From: nectonparishcouncil@gmail.com
To: [Norfolk Boreas](#)
Subject: Clarification required please
Date: 29 January 2020 09:25:11

Our ref : NORB-004

Following the site visit in 23 January it appears there is some confusion over the pegging out of Chris Allhusen's land.

Title:
Norfolk Boreas study areas

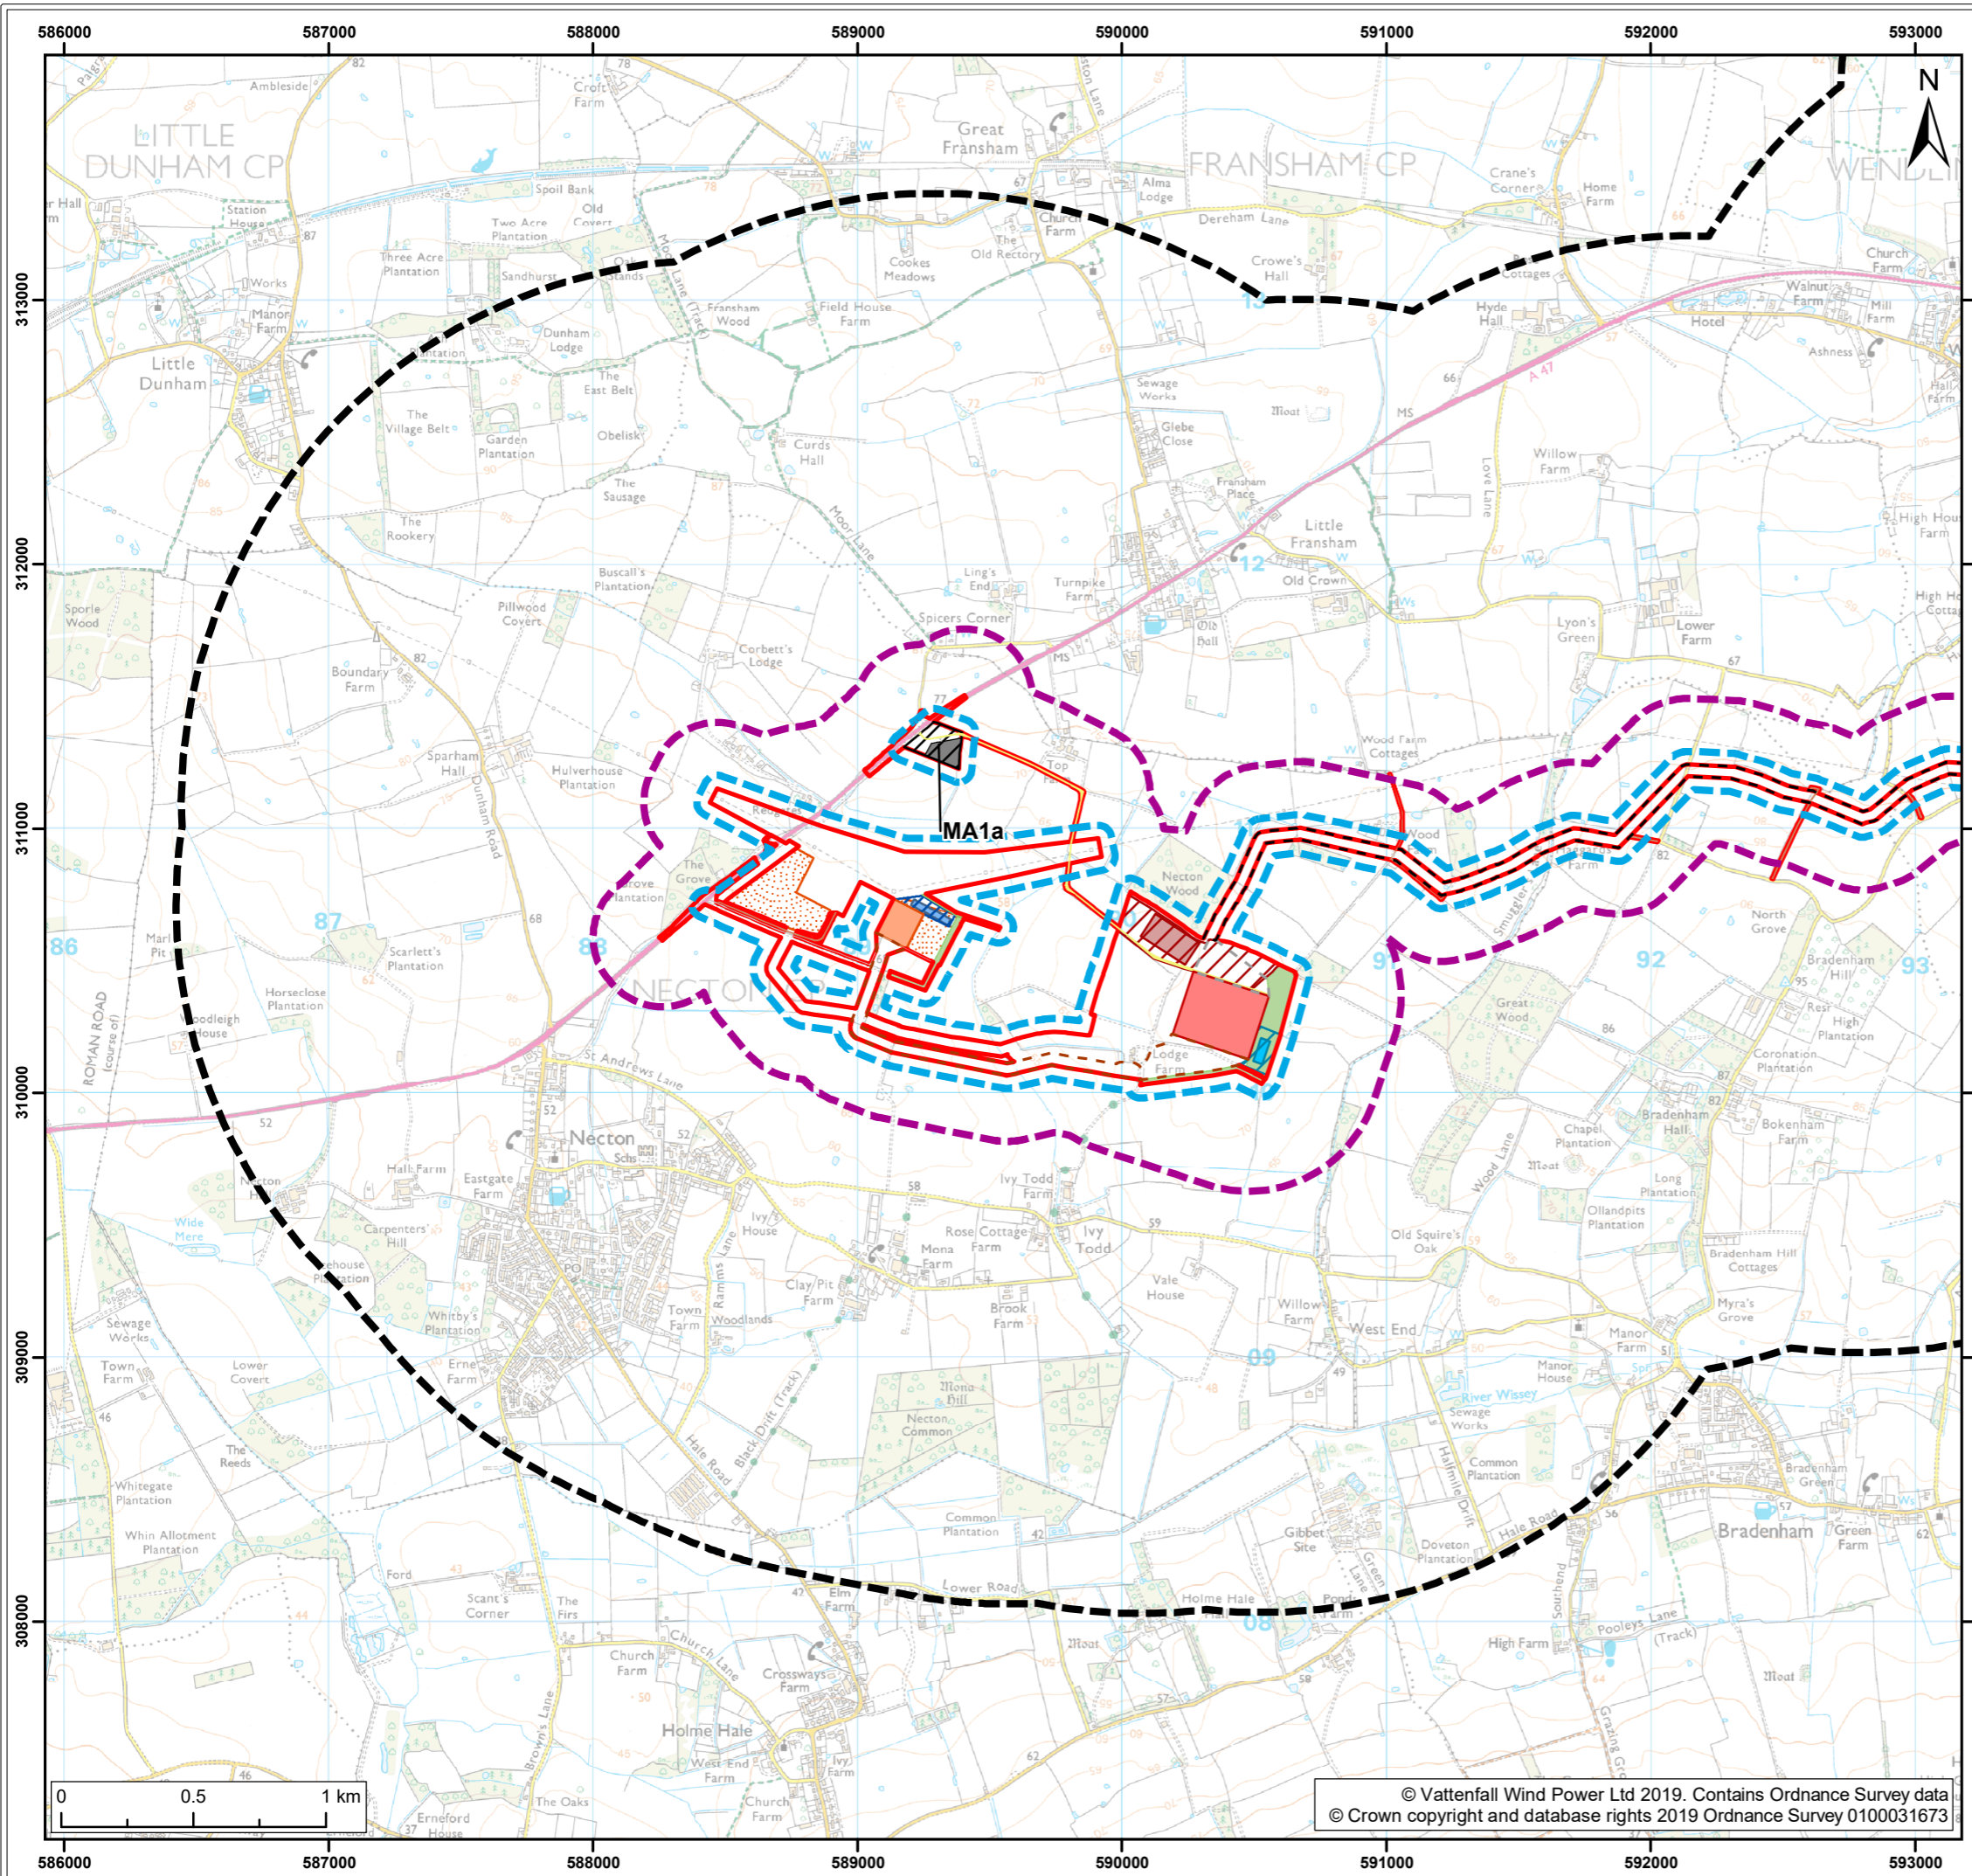
We thought it was meant to show the cable corridor but on checking the map it appears to show the edge of the compound.

Can Vattenfall please clarify what the pegging out indicates? If it is the compound, it appears to be outside the boundary.
